From: Richard Temple
Sent: 20 December 2017 11:56
To: Planning.Responses
Subject: FW: COMMENTS BY 21st DECEMBER 2017 - BR/305/17/HH 30 Mansfield Road, Bognor Regis
Importance: High

From: Bognortc [REDACTED]
Sent: 20 December 2017 11:54
To: Richard Temple
Cc: Neil Crowther; Lynette Gill
Subject: COMMENTS BY 21st DECEMBER 2017 - BR/305/17/HH 30 Mansfield Road, Bognor Regis
Importance: High

From: Richard Temple [<mailto:Richard.Temple@arun.gov.uk>]
Sent: 11 December 2017 10:37
To: Bognortc [REDACTED]
Subject: BR/305/17/HH 30 Mansfield Road, Bognor Regis

PROPOSED ELEVATIONS

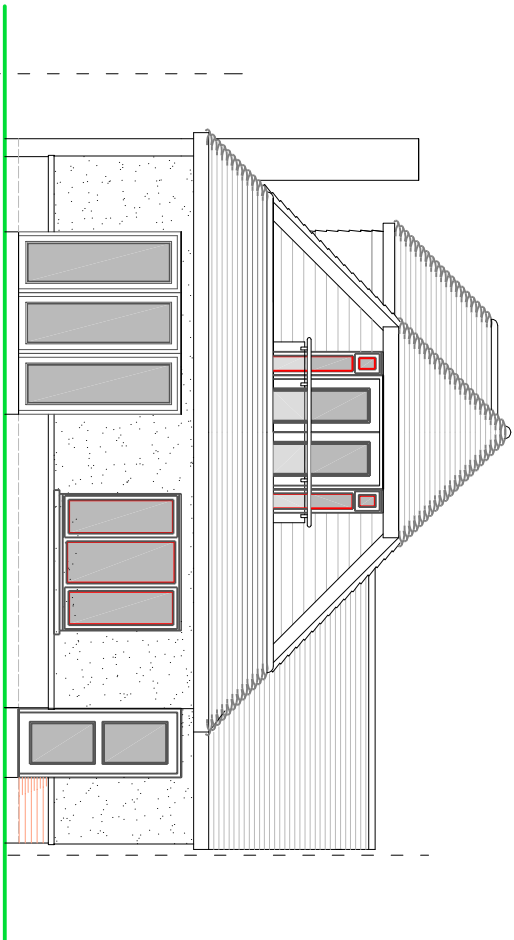
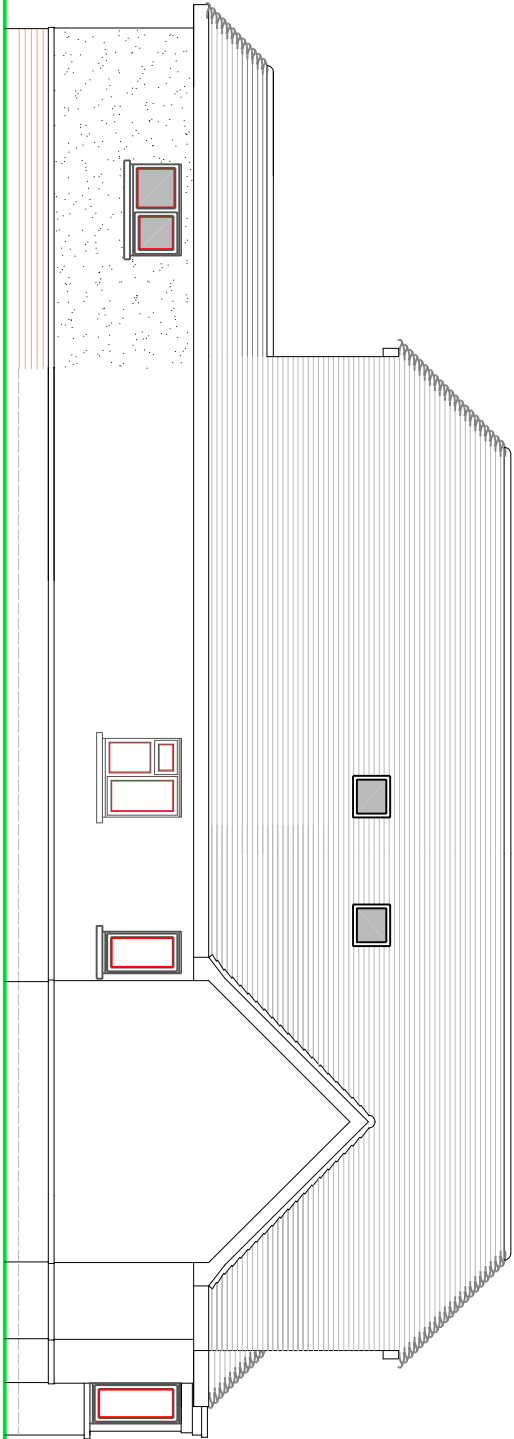
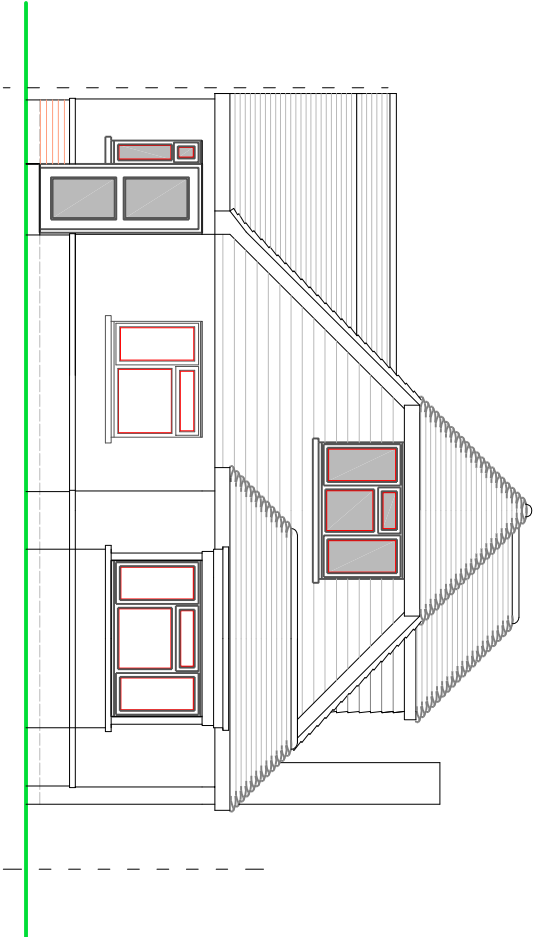
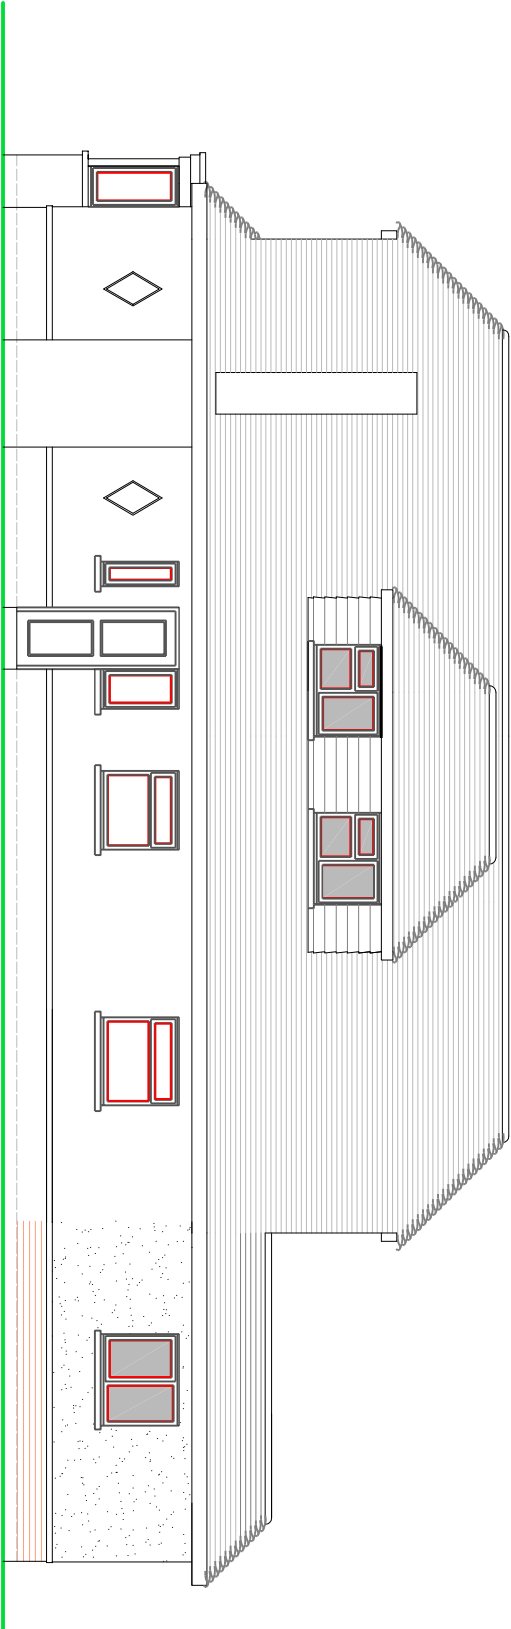
"OBJECTION. The Committee objects to the front dormer detailed in the plans as it is out of keeping with the street scene. The Committee suggested that an alteration to the plan could be considered, such as a velux window rather than the front dormer."

I require some clarity on this comment as no front dormer window is proposed by the application. The dormer proposed would be to the side and face south west. Are the committee objecting to the side dormer?

Having re-inspected the proposed plans, taking into note the actual positioning of the dormer, the Town Council's Planning and Licensing Committee have '**NO OBJECTION**' to this application.
